[REDACTED]
Sent: 26 November 2013 16:44
To: Simon Davis
Cc: Phil Hamblin
Subject: RE: 33 Chichester Road Bognor Regis BR/249/13

1. How many employees wil there be aprox?
2. Where in the car park will deliveries load/unload as this is not clear. Will it affect car parking space.
3. There are 3 existing dropped kerbs. If these are not intended for use we would expect these to be re-instated to footway. As de-mountable railing barriers are currently in situ at these access points it would be useful to know if these are to remain as they could potential be used as access points in the future.
4. I also feel that this proposal needs to be supported by a car parking accumulation survey. Would you be able to undertake a survey on an exisitng Morrisons Site which is representative of this site, or a similar site elsewhere. I would like this to be undertaken at 15 minute intervals on a weekday and a weekend day for comparrison.

NyeTimber Site 33 Chichester Road Bognor Regis (CoU)

Block Plan

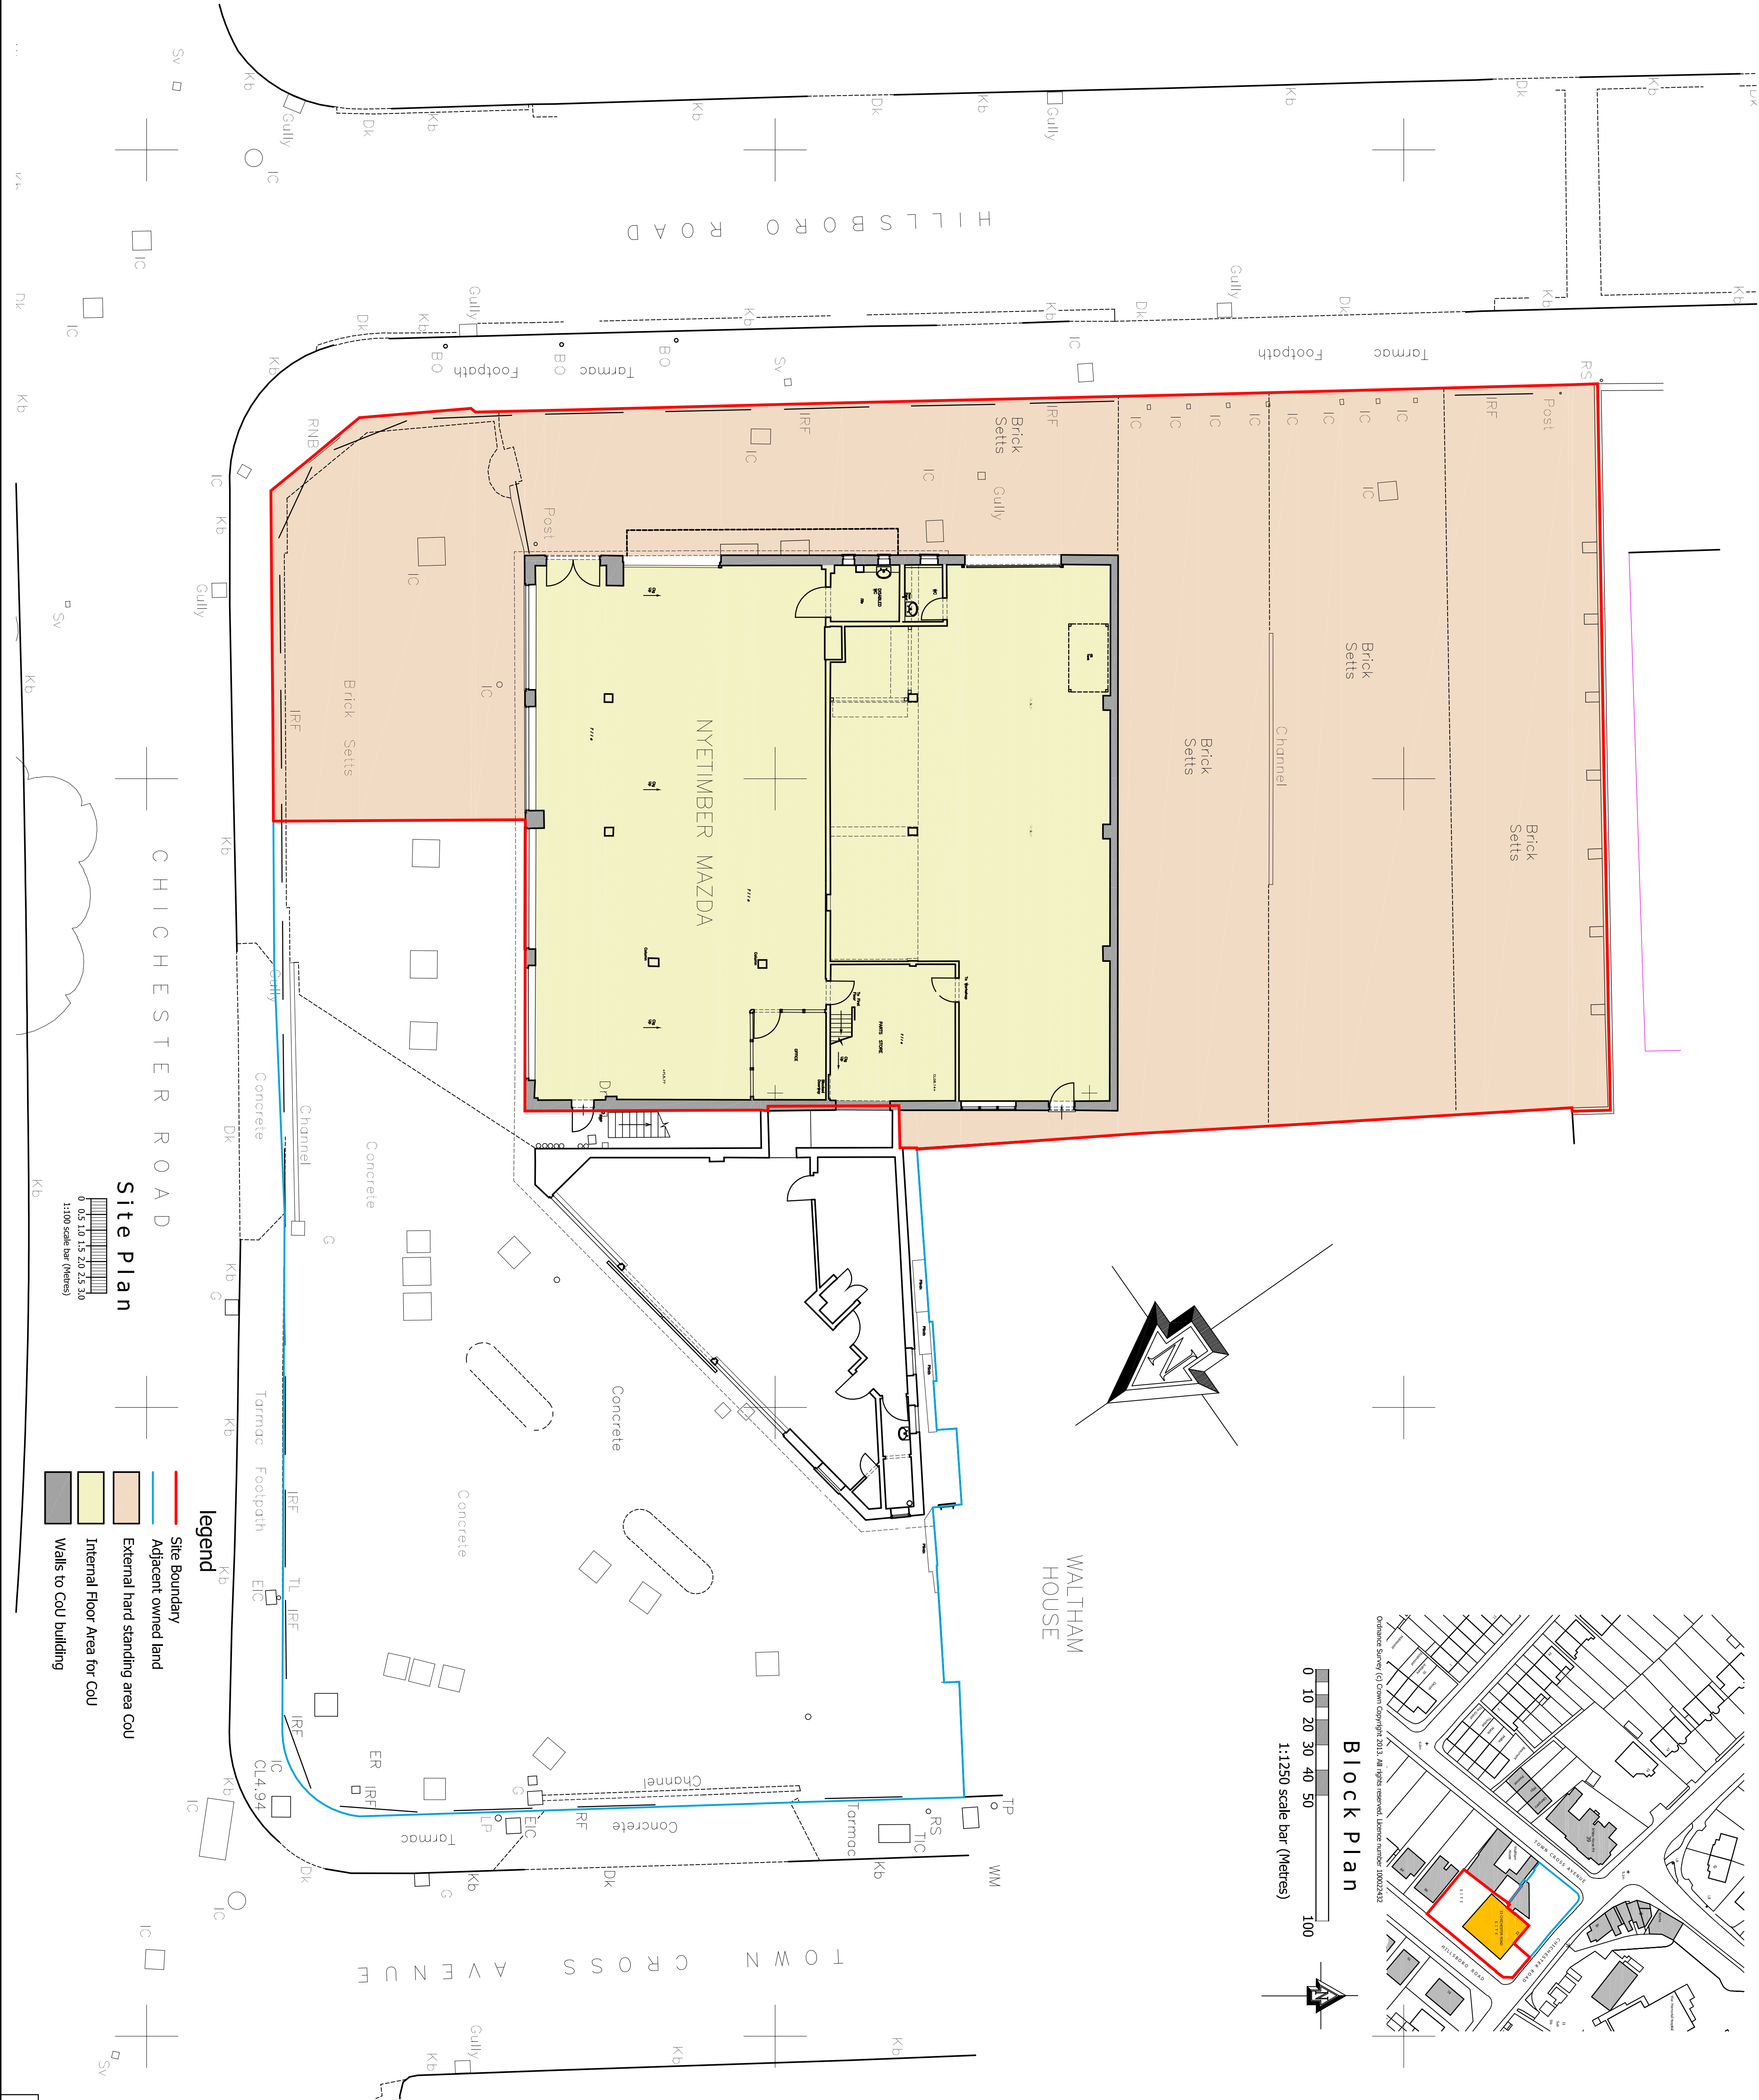
The main issues i want clarification on is the car parking and if the proposed number of spaces will meet demand. Additionally the effect any overspill parking may have around the neighbouring roads needs to be considered. I am now also concerned that the displaced parking from the garage sales will overspill onto the surrounding streets.

Q2 Deliveries will be made in the central aisle of the rear car park at times of low usage. This is quite normal with these times of establishments. Deliveries are generally organised by the premises managers at times when the shop is at its least busiest. The operator of the premises is very experienced with this type of arrangement and will have management procedures in place to ensure the health and safety of all persons on site and in the local area, thus ensuring the highway is not obscured or blocked.

Q3 Please can you clarify the 3 drop kerb points as the site for the CoU only has 2 (1 in Hillsboro Road for the rear car park and 1 for pedestrian access at the road junction) There are 2 others on an adjacent site but these are outside the red line. The removable barrier at the junction of Hillsboro Road and Chichester Road are to remain Insitu, as they may be useful at times of maintenance or if glazing needs to be repaired to the building facade, otherwise they are proposed to remain insitu
